From: Martyn White
Sent: 01 July 2019 11:43
To: Planning.Responses <Planning.Responses@arun.gov.uk>
Subject: AW/150/19/HH

AW/150/19/HH

sheet 2

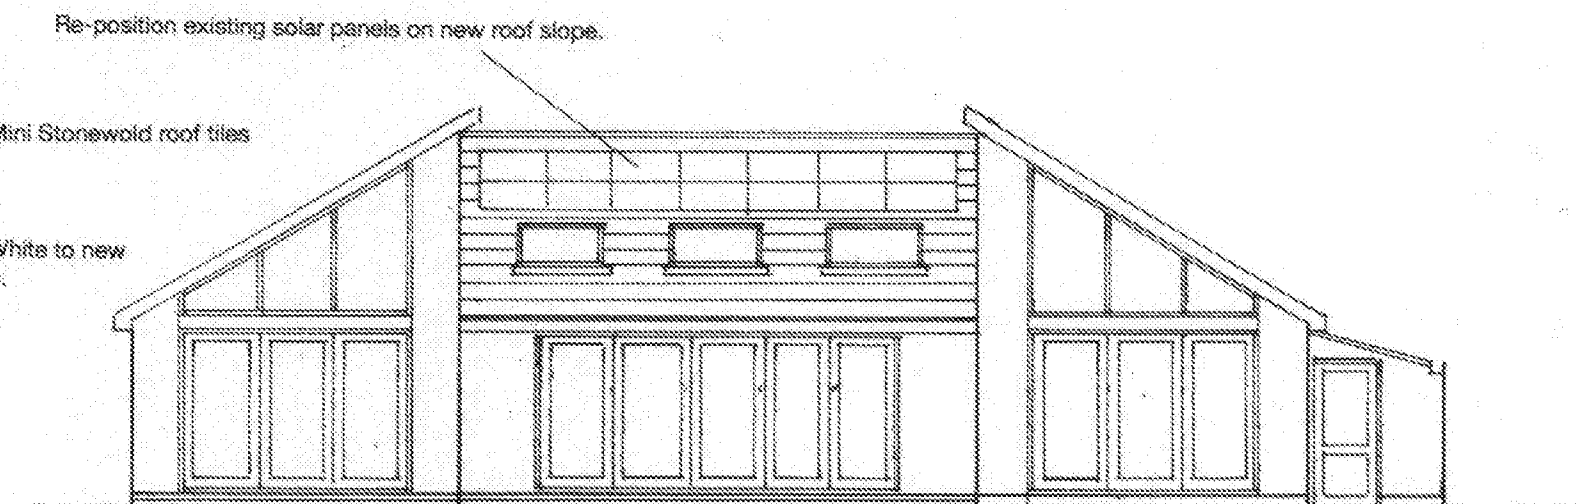
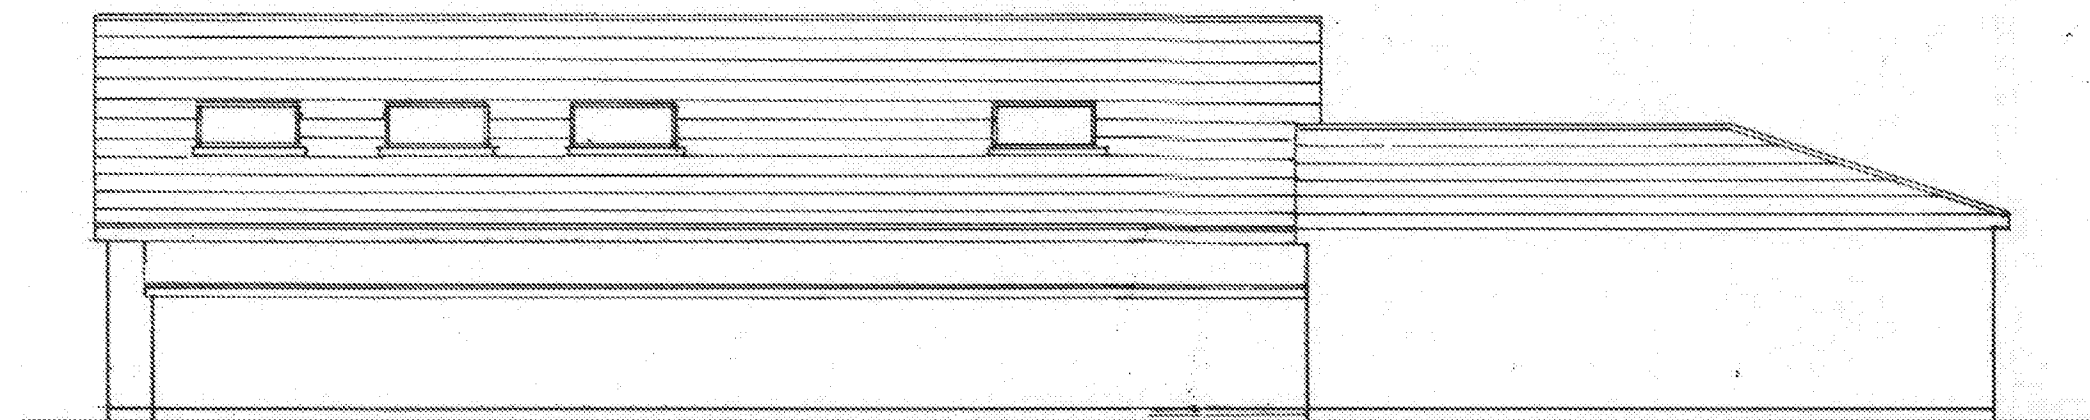
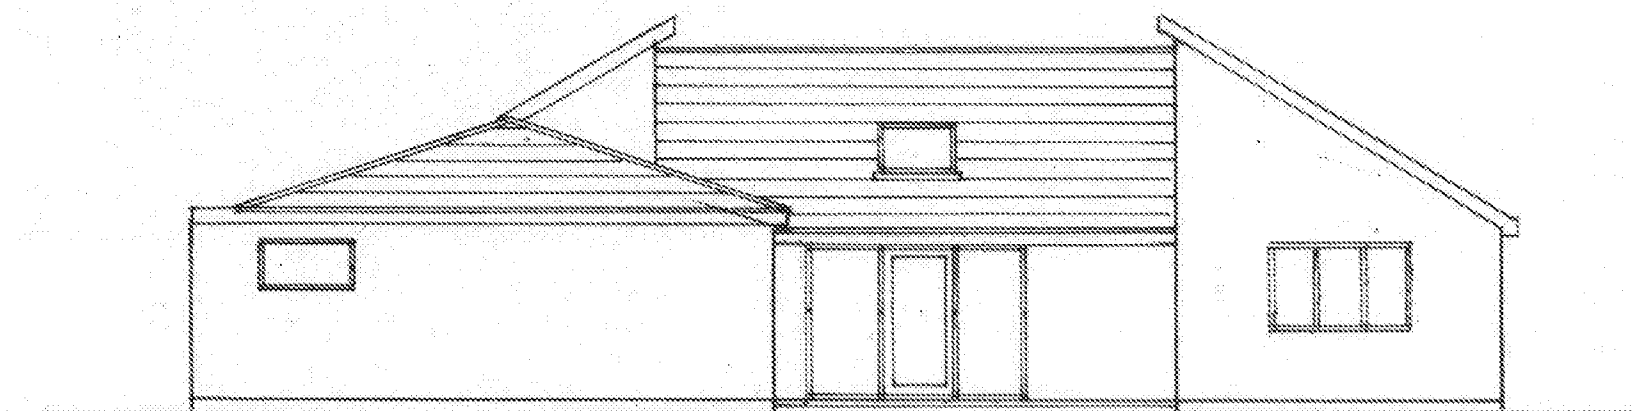
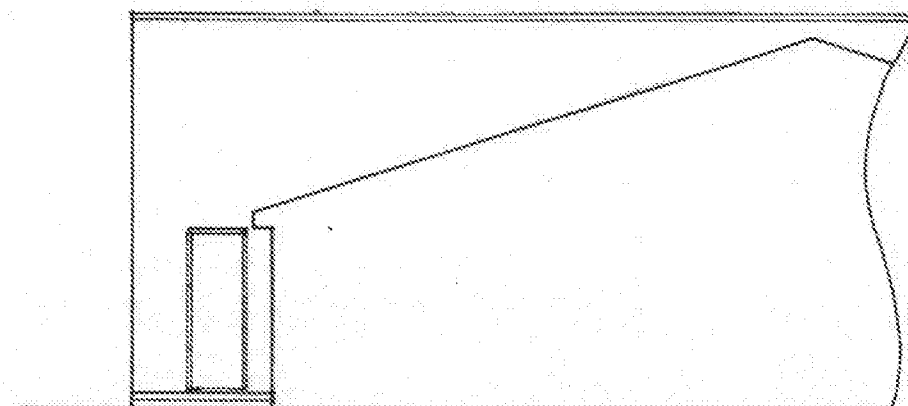
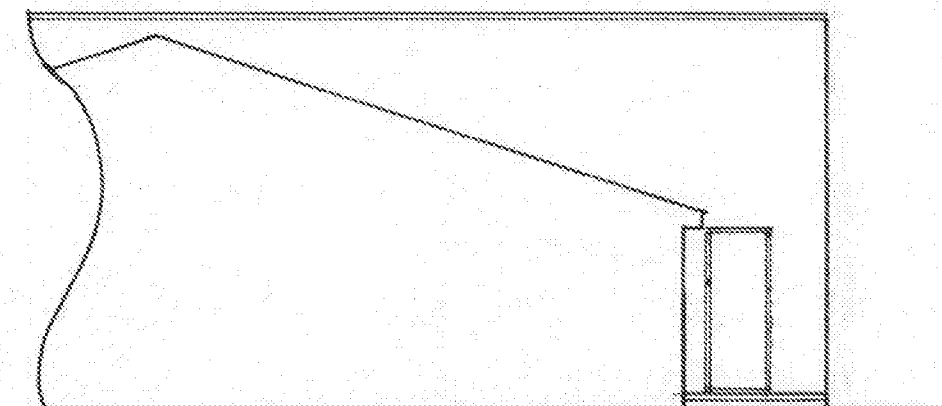
The proposal is to re-roof the entire of the building as well as to provide single storey rear & infill extensions. The alterations to the roof are substantial, and would ensure that the building closer reflects those in the local area. However, it is suggested that there aren't many properties in the local area with such a roof shape/form, and that it would be somewhat in conflict with the established character. In addition, the roof would be substantial and covered with a manmade tile that would conflict with those used on the more traditional properties in the conservation area. Whilst, a number of properties have changed their roof material to slate/slate effect grey, this proposal is still in conflict with the character of the area.

If minded to approve the application, please condition the roof lights to be of conservation standard.
